AB/109/20/HH

White Cottage 32 King Street Arundel BN18 9BW

Rear single storey extension for new kitchen and living area, internal alterations, new and adjusted windows and doors, part replacement roof structure with 2 x conservation roof lights to

PROPOSED ELEVATIONS

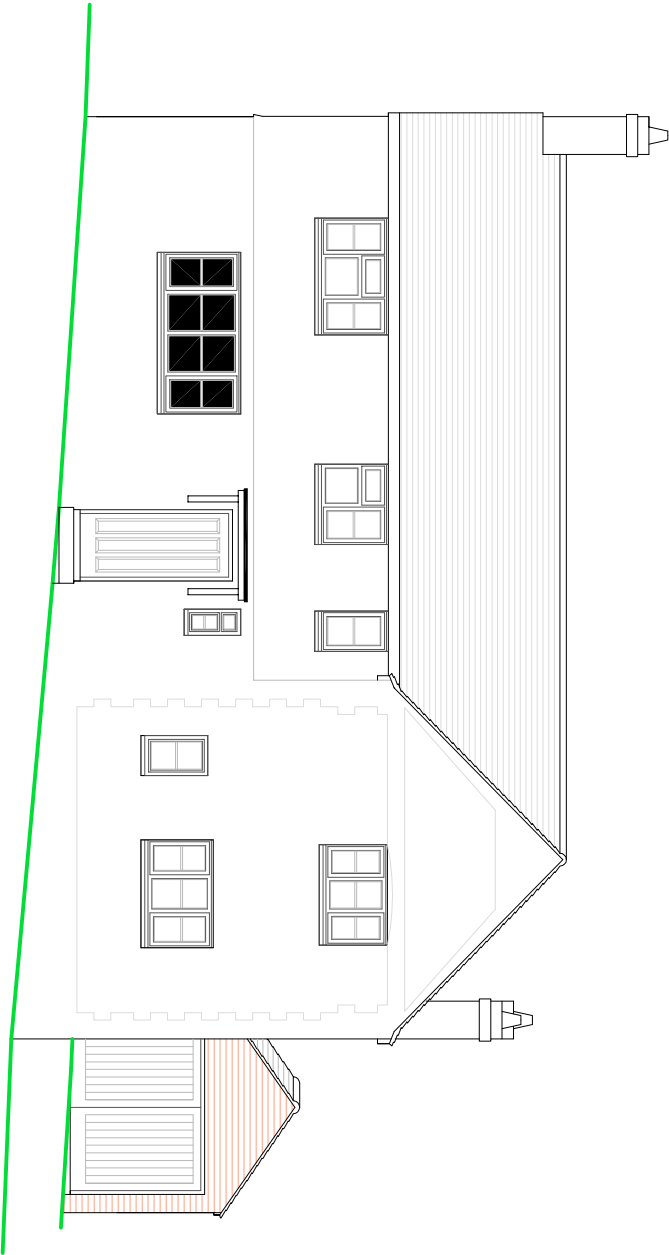
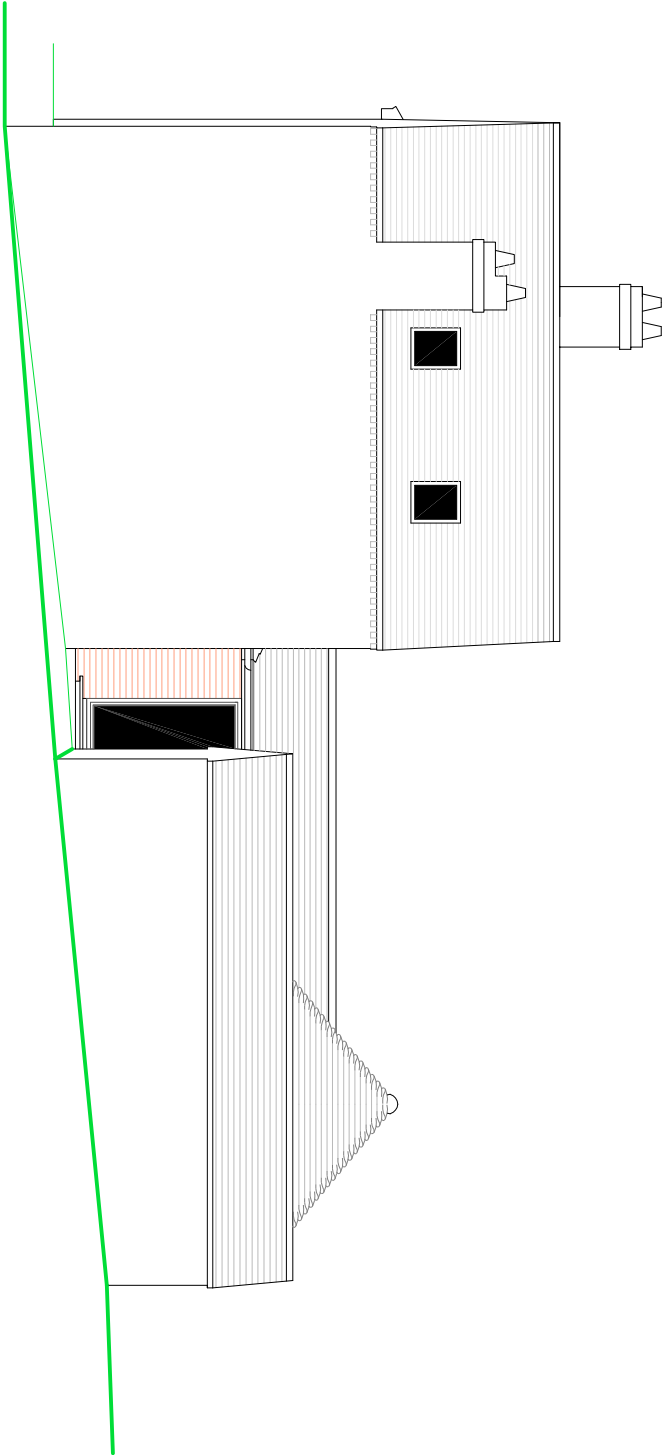
The proposed extension is substantial and will occupy a large floor area, representing a substantial part of the existing ground floor. Further, the design/size of the extension would mean that it would dominate the rear elevation of the property and be out of character. Whilst I note references to the fact that the extension would attempt to replicate the shape of a previous extension, it is not fully clear why the extension has been designed as it has been. Whilst I have previously identified that the loss of the former extension was harmful ('less than substantial harm'), it is not clear how some attempt to replicate the shape of the former structure is necessarily a satisfactory approach. This is especially when the positive features of that construction do not appear to be present in this proposal. It is suggested that an alternative design could be prepared that would have a more positive impact.

I am also concerned to see the removal of the clay tile hanging tiles from the front and rear elevations and their replacement with a painted render finish (as seen on the elevation plans). Historically, tile hanging is particularly associated with Kent, Surrey and Sussex. The style was used more widely in the late 19th and early 20th century under the influence of the Arts & Crafts movement. Its inclusion on this particular property forms part of the established appearance and therefore character of the building. Its loss would detract from the building, especially the front and street elevation.

The replacement windows would also be of a different appearance; at present they are leaded timber or metal windows. The use of UPVC in a conservation area and a positive building is unfortunate, especially in a road where so many of the surrounding buildings are listed (i.e. designated heritage assets).
